From: Jason Wall <jwall@ausgrid.com.au>
Sent: Friday, 16 November 2018 5:38 PM
To: Melissa Prochazka
Cc: Keiran Fleming; Property; Paul Nakhle
Subject: RE: Request for SEARs for Orica Southlands Warehouse Estate (SSD 9691) - 28 McPherson Street, Banksmeadow.

Re: Request for SEARs – Orica Southlands Warehouse Estate (SSD 9691) – 28 McPherson Street, Banksmeadow

**Orica Southlands Warehouse Estate (9691)
Comment on the Secretary's Environmental Assessment Requirements (SEARs)**

Drawing: **SITE PLAN - OPTION 6**
NO ACCESS VIA NANT STREET
Scale: 1: 1500 @A3 Project No: 180101 Drawing No: SK - A 106 Issue: P4
Drawn: AA Date: Jan 2018

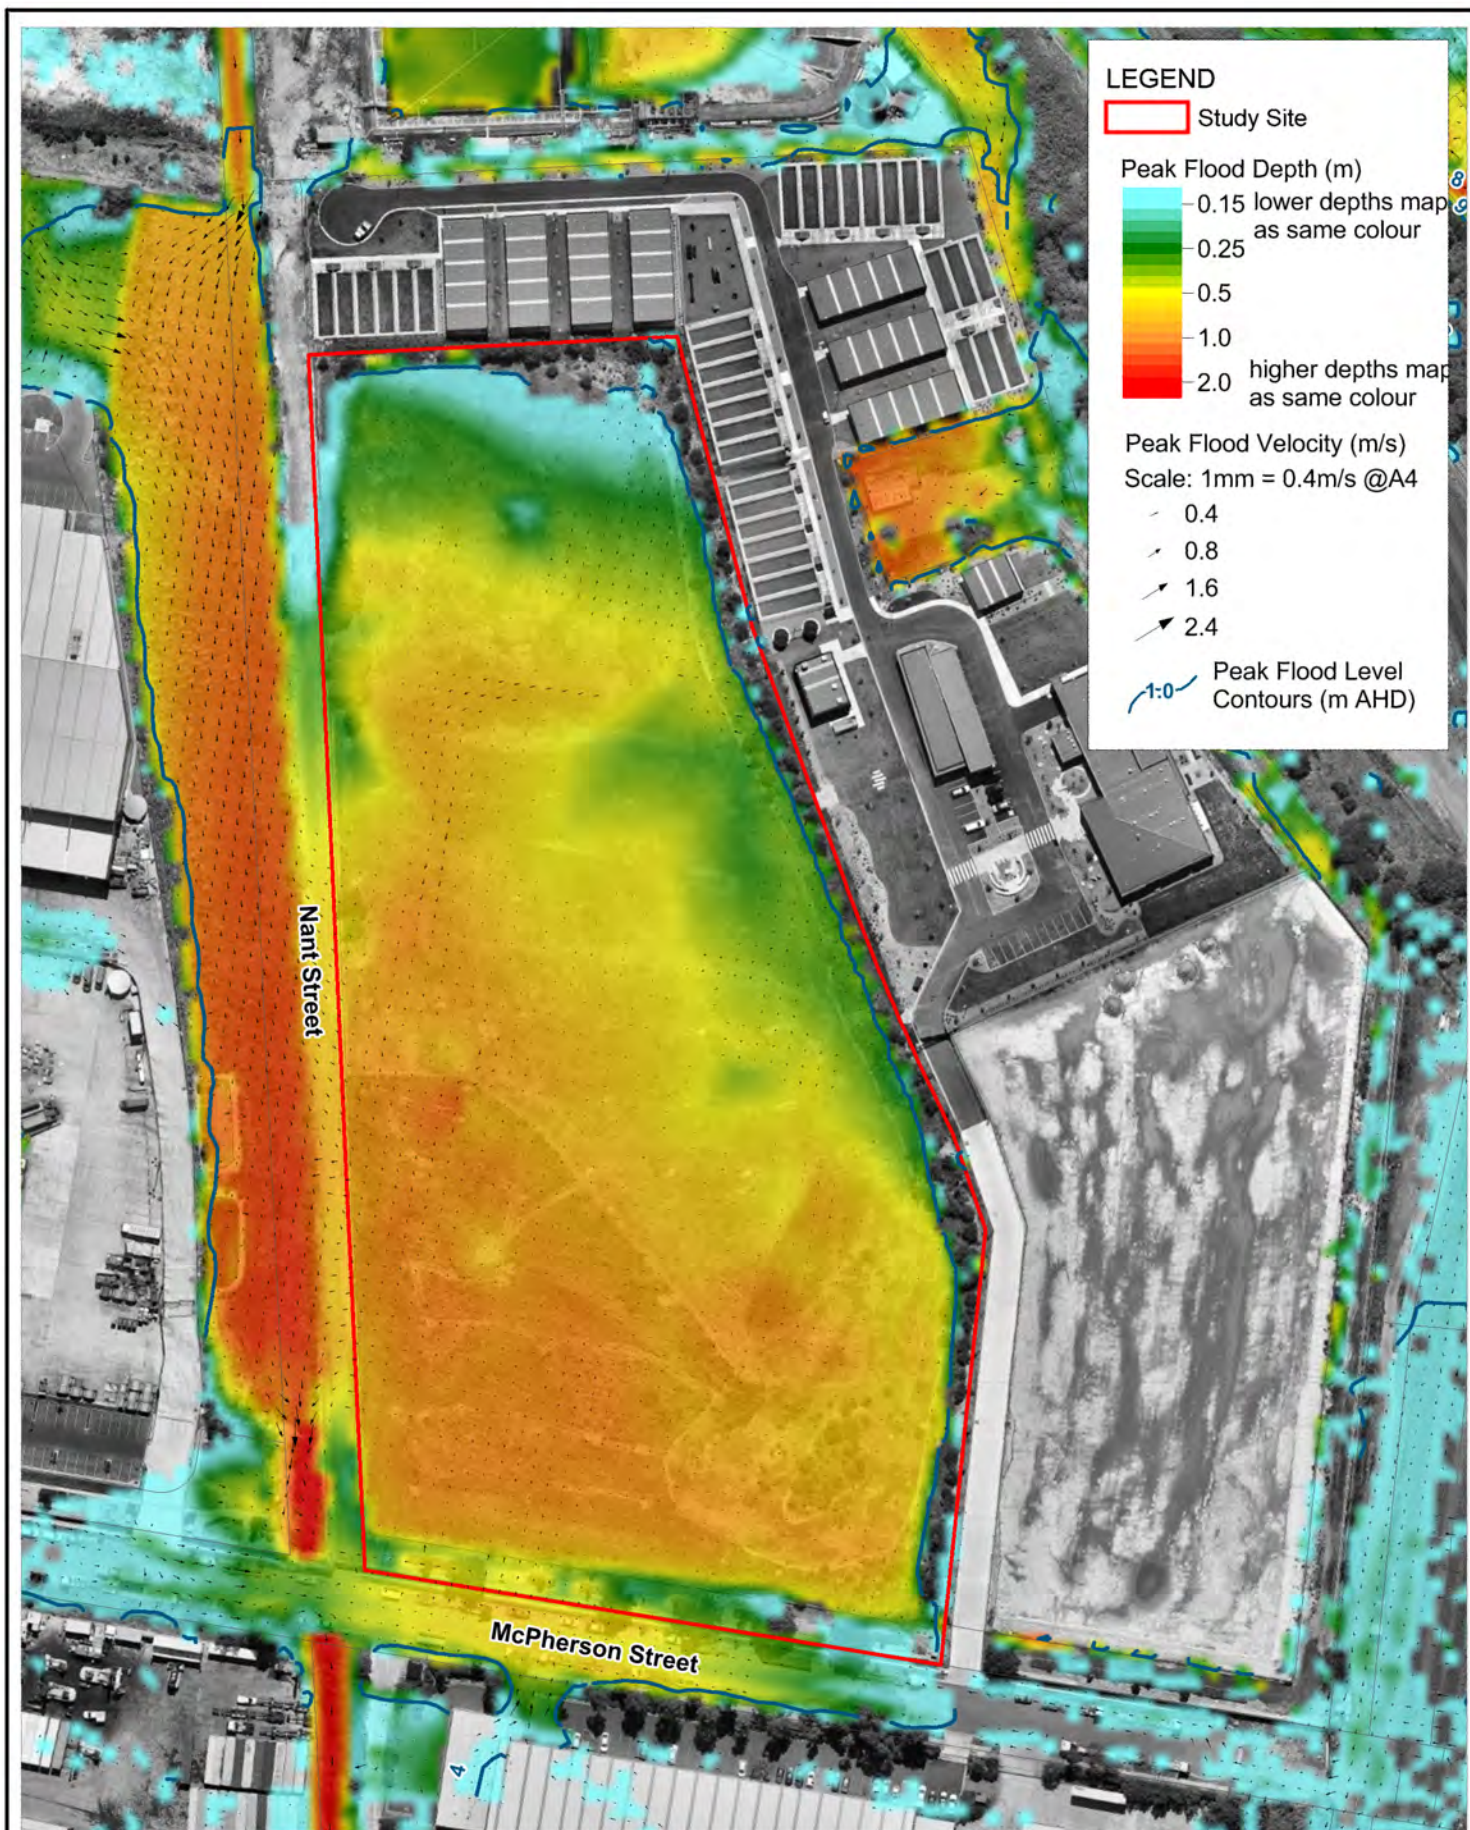
The raising of Nant Street and the use of culverts under the raised road has not been modelled. The model only shows the ramps being raised and the remainder of Nant Street remaining at its current level.

To provide access to the site in flood events (even relatively minor flood events), Nant Street would need to be raised in its entirety. Furthermore, if there are multiple culverts there is a risk of blockage, and the modelling doesn't account for this. Further information on this should, therefore, be included in the flood study in the EIS

The applicant also needs to clarify whether the entirety of Nant Street will be raised or only where the access ramps are proposed. The text in the SEARs appears to conflict with the hydraulic modelling that shows no change in depth for the majority of the road (with only the ramps raised).

Council also has concerns regarding the location of a new access way (road) in close proximity to the drain, which is in a high velocity flow area (floodway). This creates a hazard for road users, accessing the site. The applicant should provide an assessment of the risk of the proposed Nant Street access as it relates to vehicles and pedestrians/cyclists accessing the site during a flood event. This should include analysis of alternative access points.

PODIUM SLAB PLAN - STAGE 1

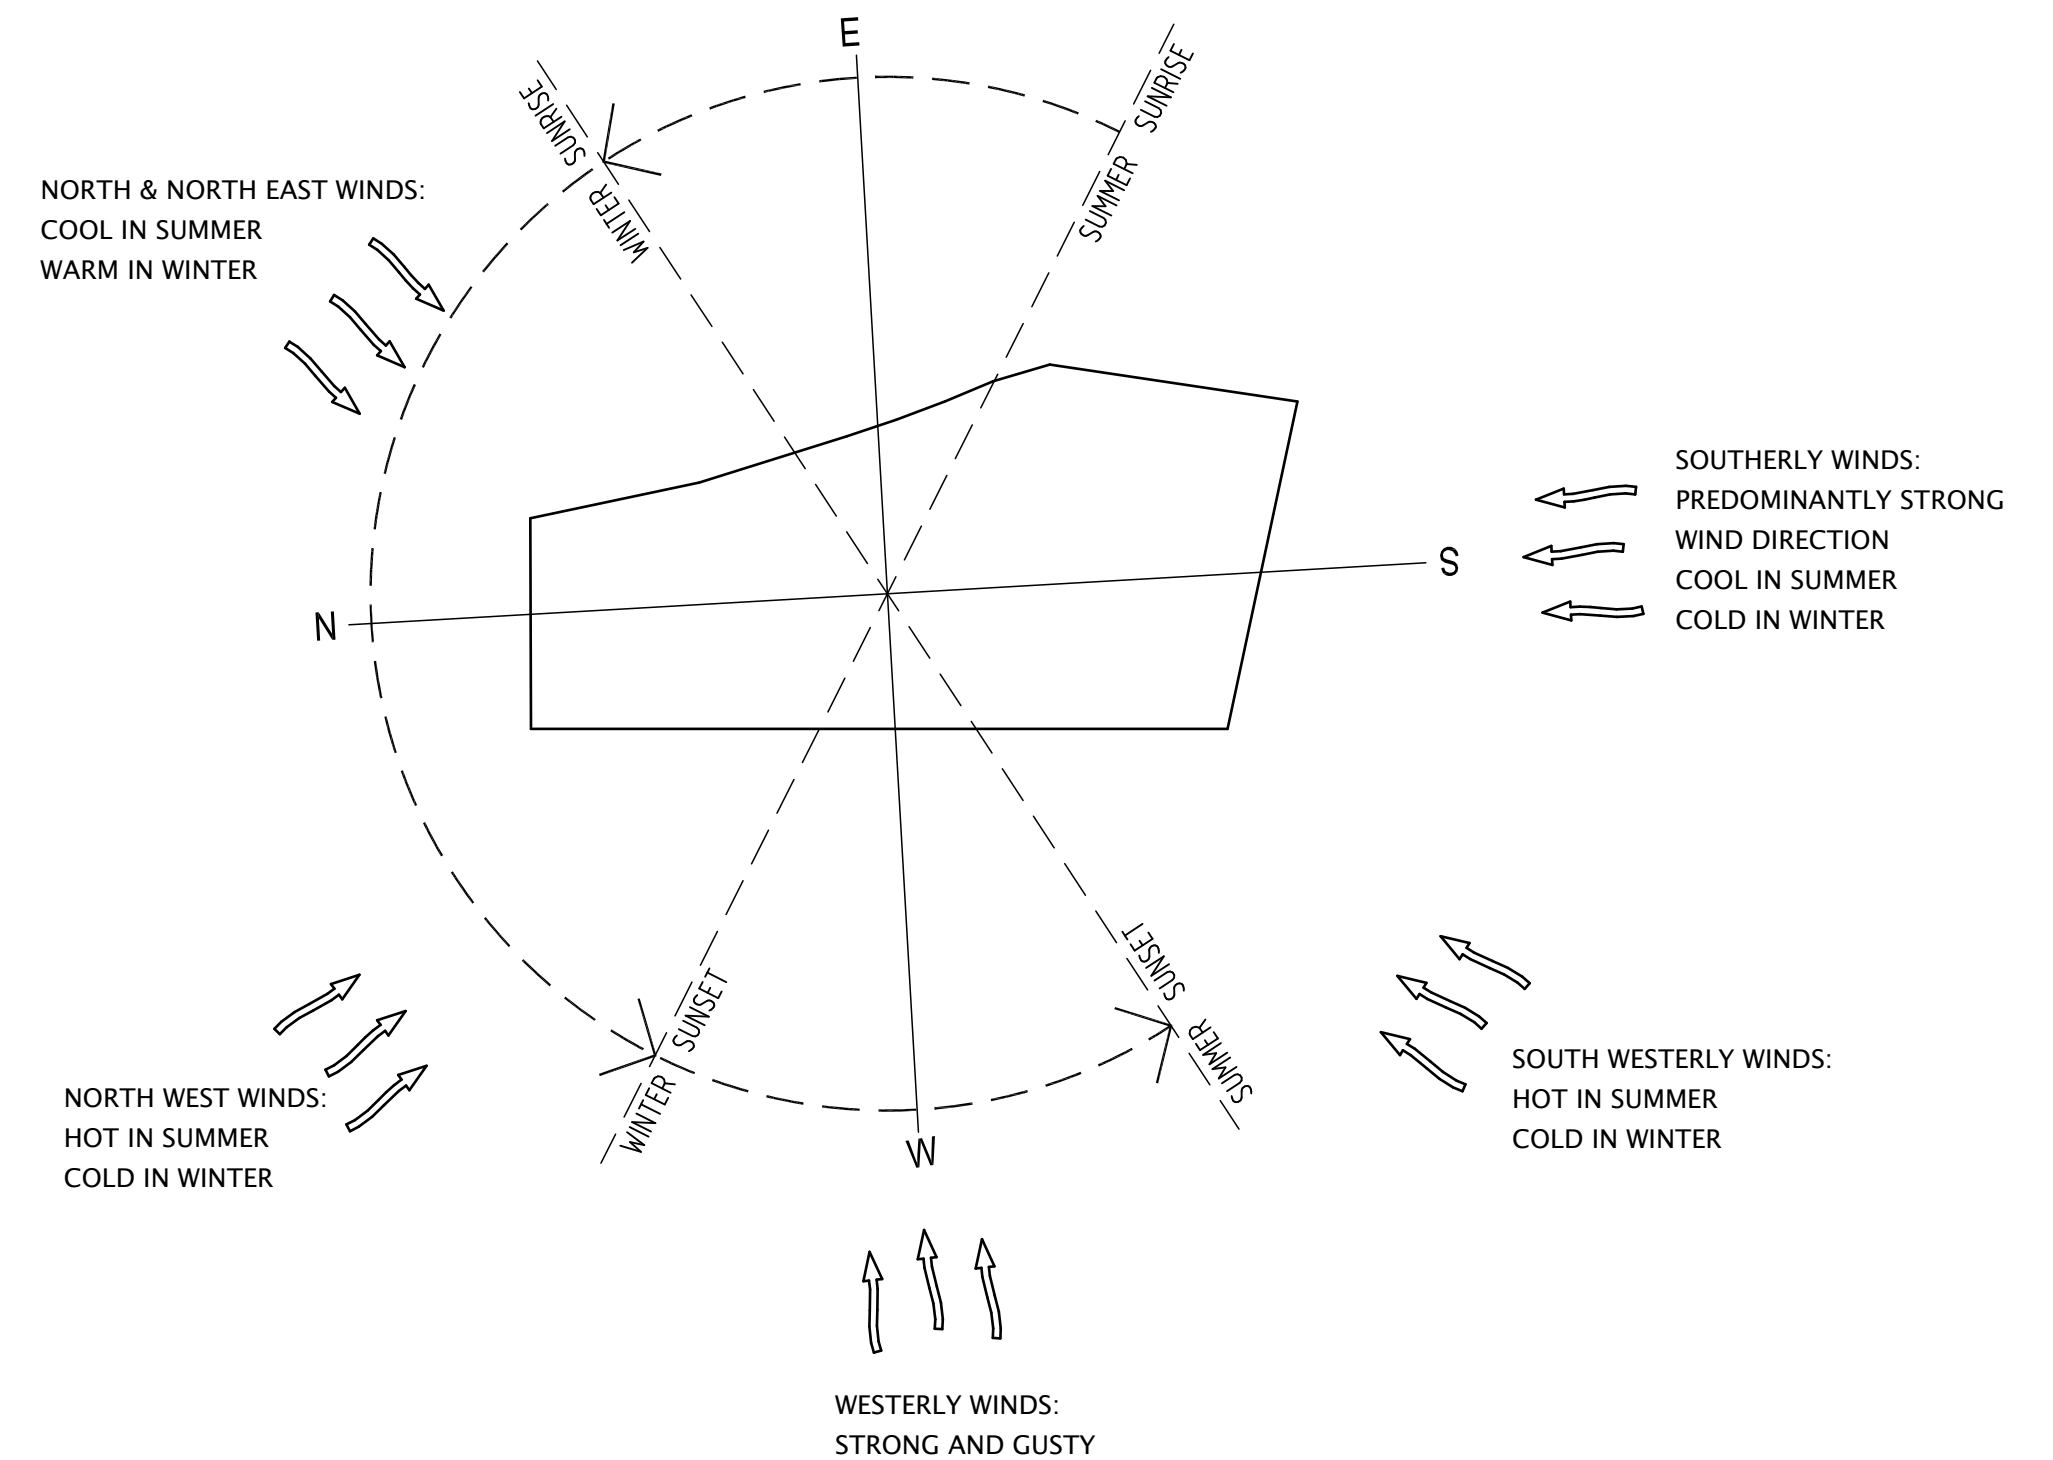
As detailed above, the restriction on the use of land and positive covenant affecting the site states that, inter alia, the owner must not use the land at grade within the Easement Site for any purpose except the maintenance of the flood detention basin located within the Easement Site. Strictly speaking, the ramps to the raised concrete platform and the piles supporting the platform will be at grade. In addition, the cross section on drawing SK – A 202 submitted in support of the SEARs request would appear to show most of Warehouse 2 situated at grade.

As well as the flooding implications of these at grade structures mentioned in the 'Flooding' section below, the applicant also needs to explain what the legal implications are of the inclusion of these structures at grade. The use of the land at grade for purposes other than for the maintenance and management of the flood detention basin is contrary to Condition 8A of Modification 2 of the Approval. The use of the land at grade within the Easement Site for any purpose except the maintenance of the flood detention basin located within the Easement Site will be contrary to clause 5.1(a) of the Section 88B instrument. The introduction of uses or activities conducted on the Easement Site could possibly interfere with or affect the maintenance of the Easement Site for the purposes of a flood detention basin, which would be contrary to clause 5.3(b) of the Instrument.
